RE: Design Review Panel (DRP) – Wednesday 17 June: Meeting 6 (Stage 3 Post Lodgment)

Green Square Town Centre HDA Scheme - SSD-83899206

TOWER FACADE

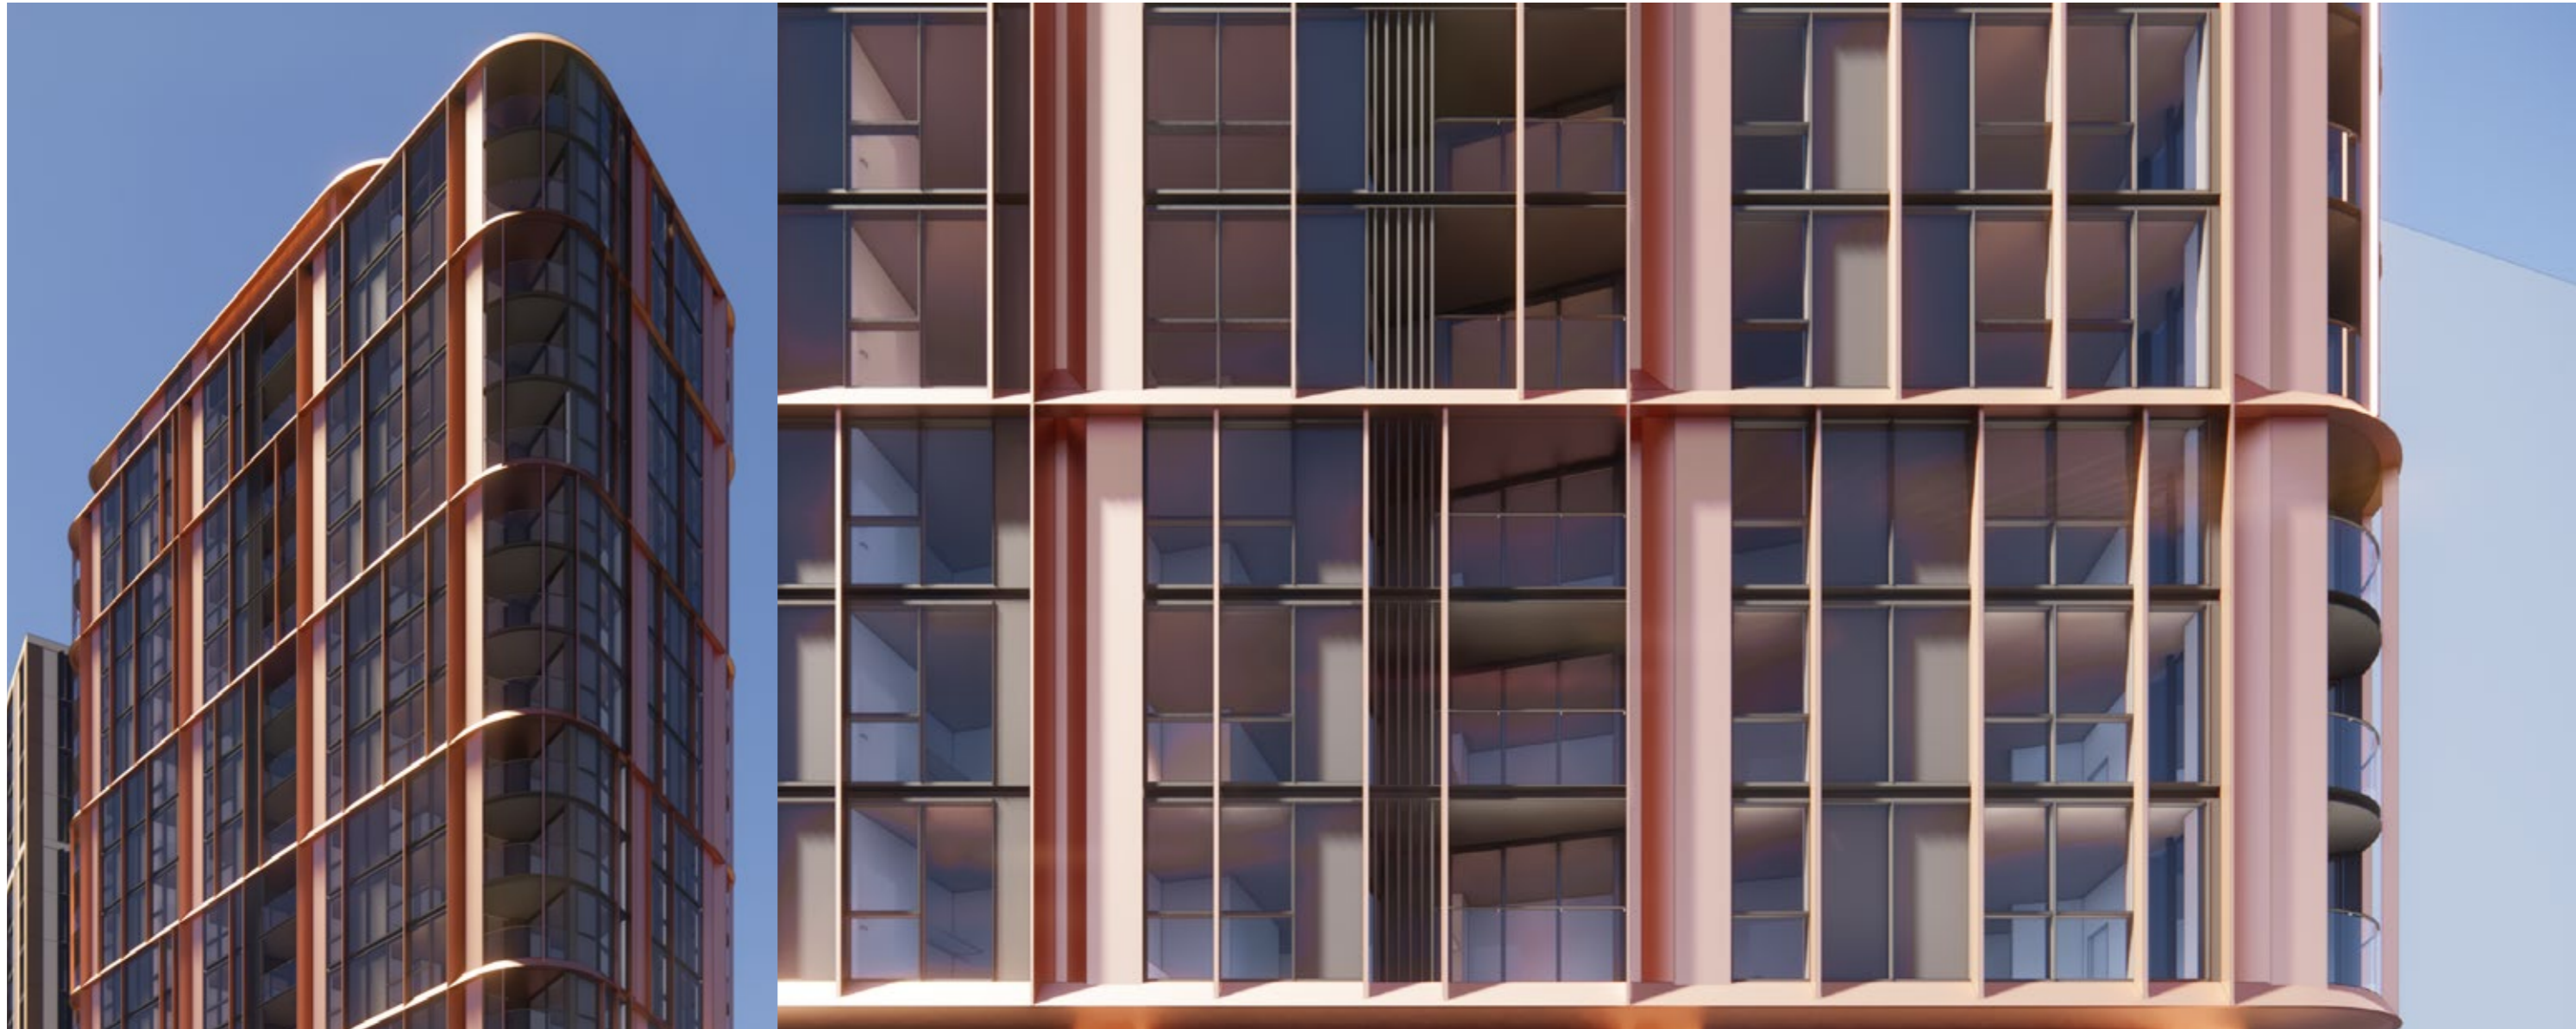
13. Notes the significant extent of glazing across the Site 18 façade and recommends that environmental performance, particularly the capacity for self-shading, be considered.

14. Recommends further details of the proposed glazing be provided for all towers with information relating to the selection of glazing and colour of the spandrel panels and full height opaque glazed panels.
